Application for a non-material amendment following a grant of planning permission.

Number	44
Suffix	
Property name	Paddock House
Address line 1	Ferringham Lane
Address line 2	
Address line 3	
Town/city	Ferring
Postcode	BN12 5LU
Description of site location must be completed if postcode is not known:	
Easting (x)	509369
Northing (y)	102264
Description

Variation of condition approved under FG/115/17/PL relating to condition 2-plans condition.

Reference number: FG/50/21/PL

DRAWING TITLE
Unit 2
Proposed Plans and Elevations

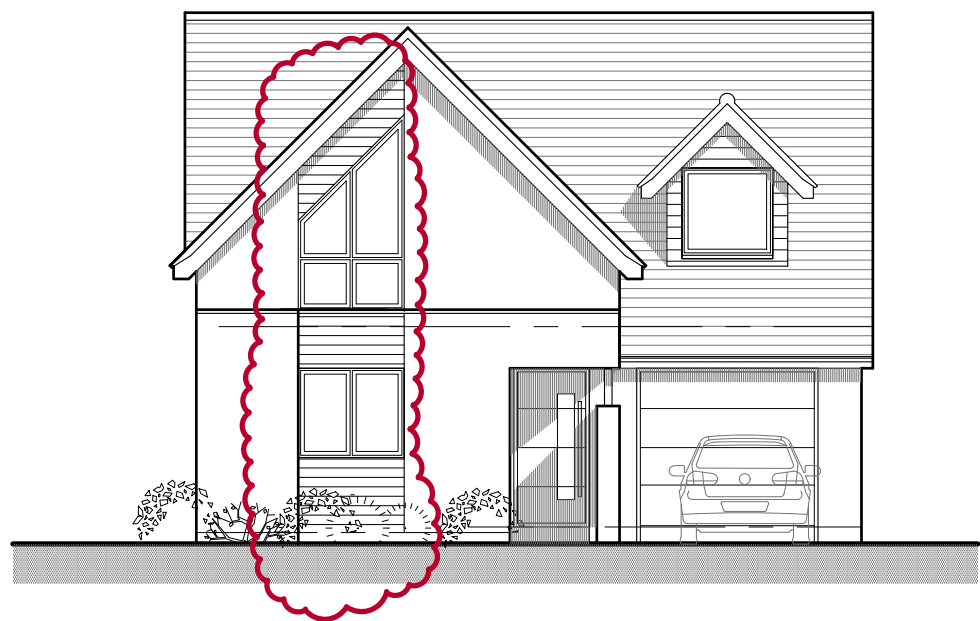
•Plot 2 – Amendments to front elevation. An area of timber boarding has been added to the front elevation. We have attached revised drawing 2007-2.02 revision C

Unit 4
Proposed Plans and Elevations

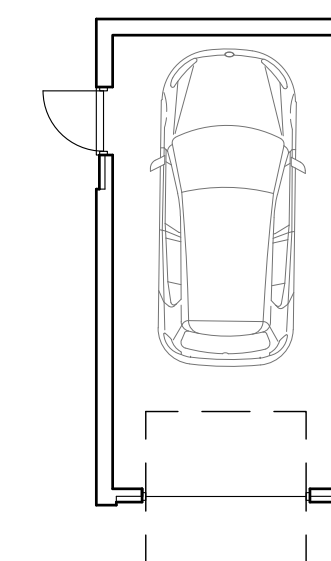
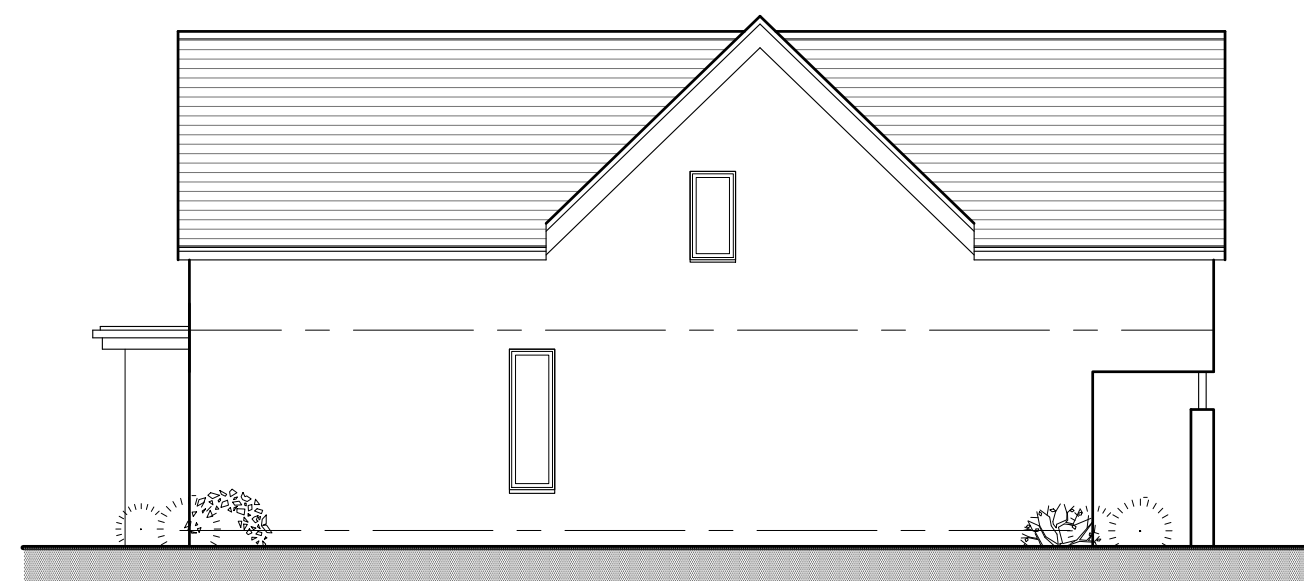
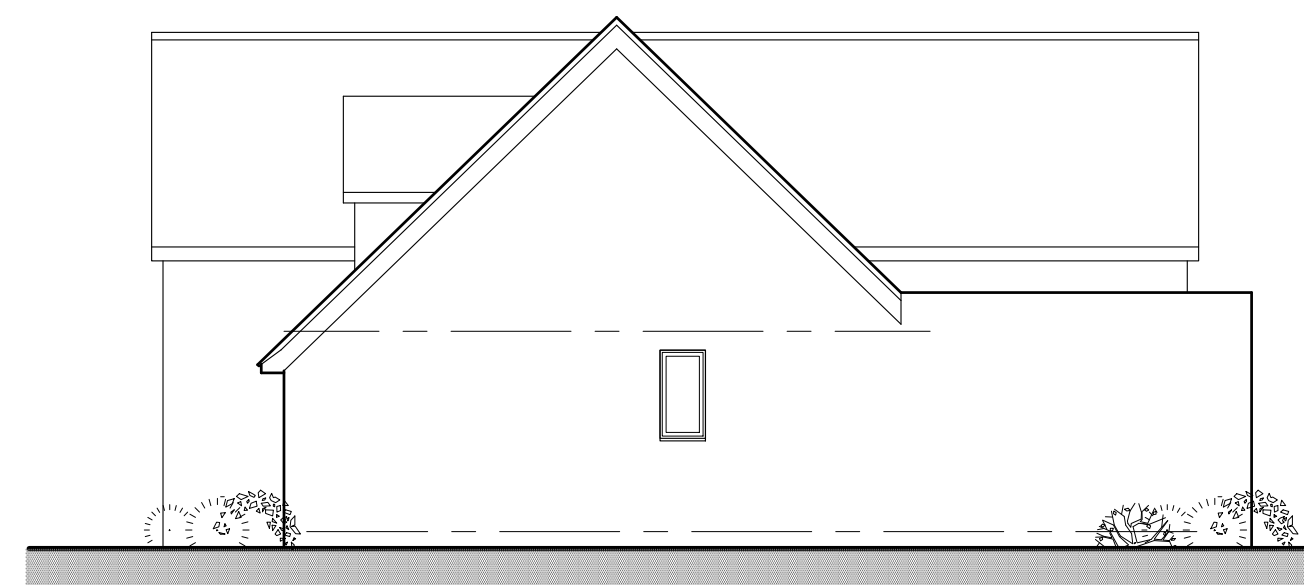
•Plot 4 – Amendments to garage design. The areas of cladding adjacent to the garage doors have been changed from timber boarding to stacked slate cladding to match the front elevation of the house. We have attached our revised drawing 2007-2.04 revision B

DRAWING TITLE
Unit 1
Proposed Plans and Elevations

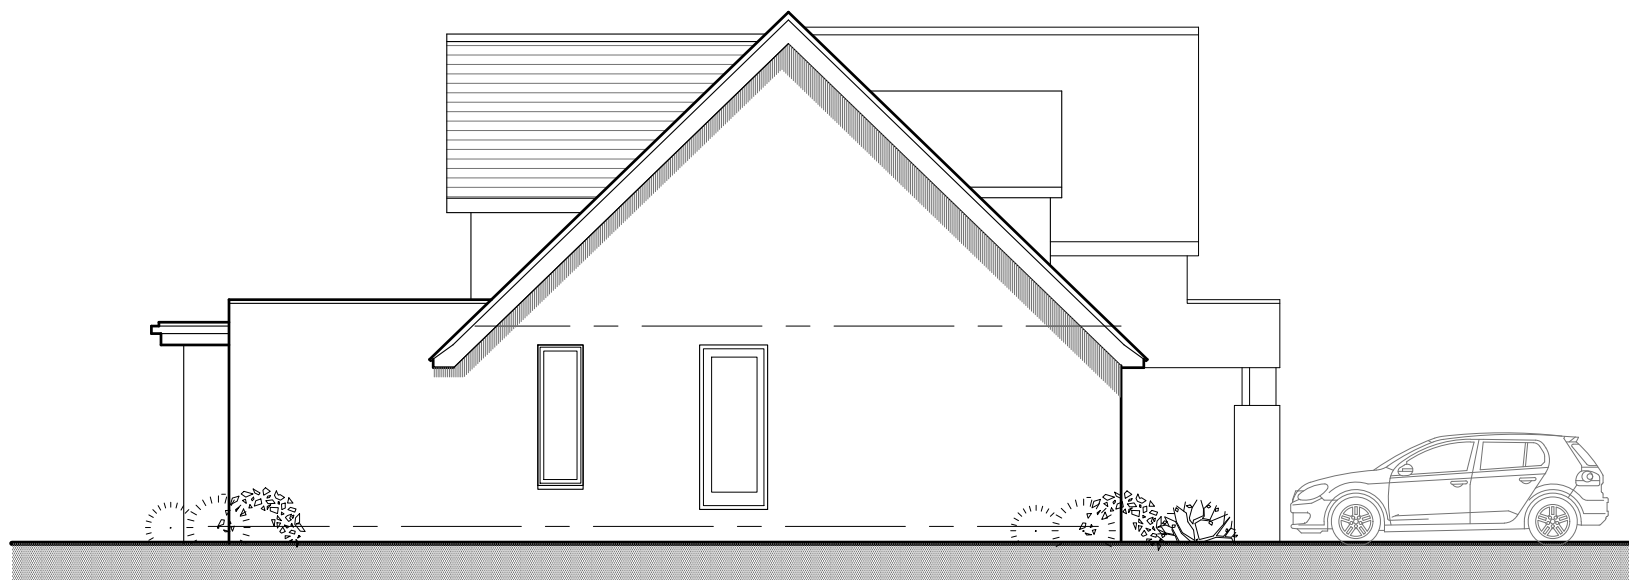
•Plot 1 – Amendments to front elevation. On the approved drawing this was incorrectly shown and did not accord with the floor plan and street elevation. We have attached revised drawing 2007-2.01 revision C
